From: Amanda Scholes on behalf of Planning.Responses
Sent: 26 November 2019 08:43
To: Planning Scanning
Subject: FW: Springfield House - R230/19/PL

In the meantime I note that the Drainage Engineer has made the following comments : It is assumed that the pool is open and not covered. If it is covered then it will need to be accounted for in the Surface Water Drainage Design. This has not been confirmed.

Title			Proposed New Foul Drainage		
Scale	1:500	At original	A4	© Robert Clark Associates Ltd	
Drawing Number	1772/F/SK2		Revision		-

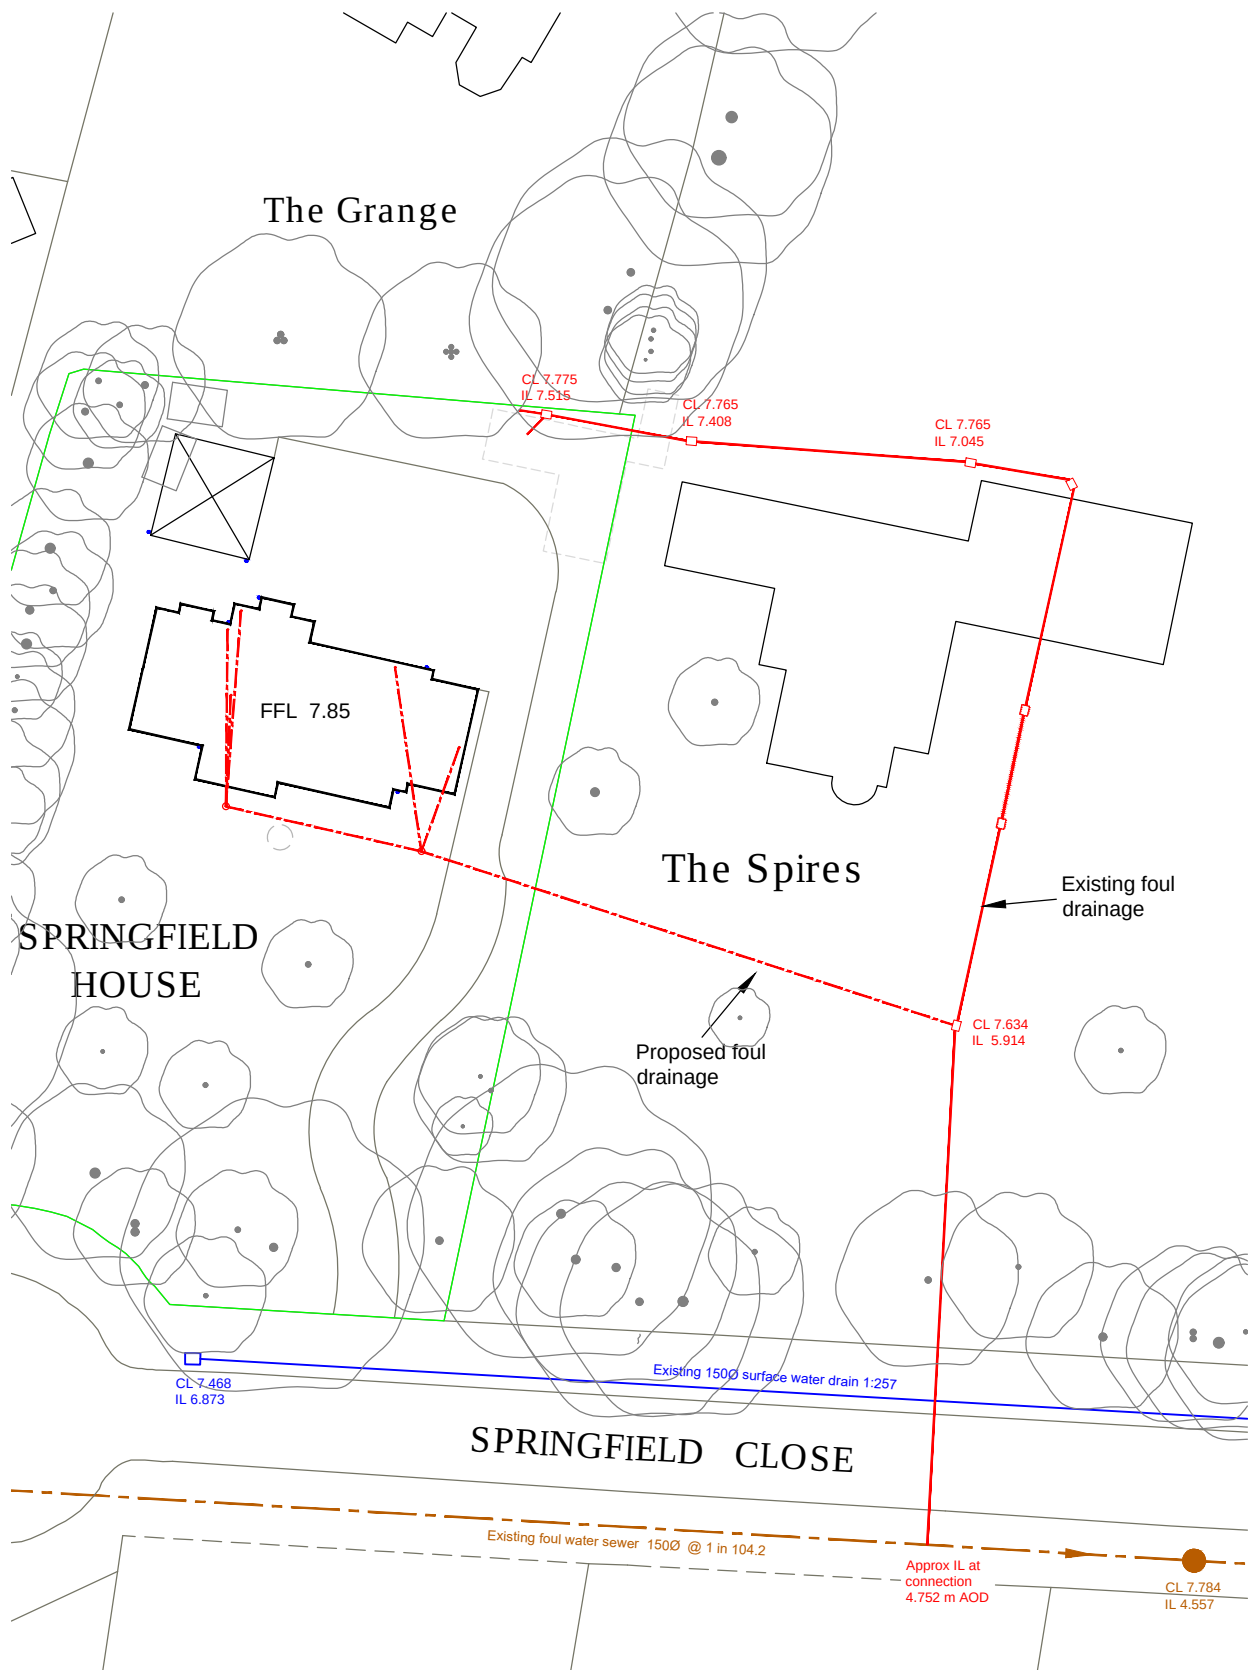
No information is given for how the pool will overflow and backwash. It is assumed that this will go to the foul sewer but this is not shown on the Foul Drainage Drawing. Southern Water will need to be consulted if this is the case. The foul drawing also shows the formally approved 2 bay garage which this application removes. The proposed 3 bay garage is not shown.
